Re: BP# 2016-02646_37 Fleetwood

Douglas Moore (co-owner 37 Fleetwood St.)

I am contacting you in regard to the drawings that you submitted for 37 Fleetwood Street.

37 Fletcher St Portland, Maine

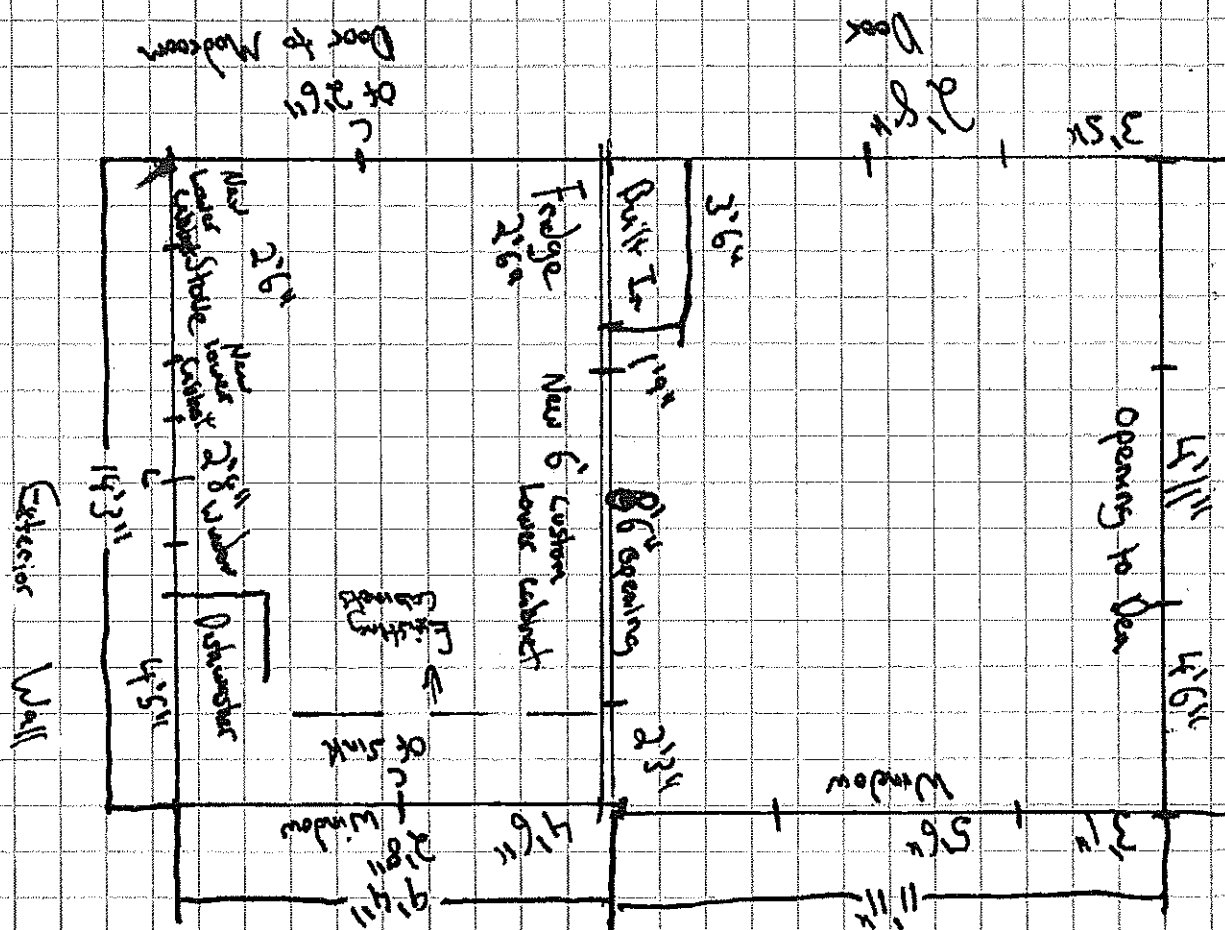
Please provide clearer floor plans showing walls with depth, clearer window locations, doors with swing and a full layout of all floors being worked on.

Please provide framing details of any new walls going in as well as the connection and support of the new lvl beam. also supply the specification of the new LVL beam

Provide a window and door schedule for any new windows and doors going in and call out headers as required for any new framed openings.

1. Please provide clearer floor plans showing walls with depth, clearer window locations, doors with swing and a full layout of all floors being worked on. Please find the two-page pdf document (attached) containing the floor plans as well as several photos of the interior wall upon which the modification will take place (see *Notes: - next*).

iii. The *sole* structural change to this home will be to one *interior* wall that divides the kitchen and dining room. This wall contains a doorway. This opening (the doorway) will be extended on one side, at the top (at eye level), to increase visibility between the two rooms. An LVL beam will be inserted above this opening to serve as a header to carry the load.

Framing- Replace supporting wall with two 9 1/2" LVLs spanning approximately 10'. LVL's will be screwed together with high strength GRK fasteners and posted with 3 2*4 KD on both sides of the

beam. The posts will sit directly on the beam below (There is a beam in the basement under the wall which work is being performed on). When framing, work is completed the beam and wall will be covered with ½" sheetrock.
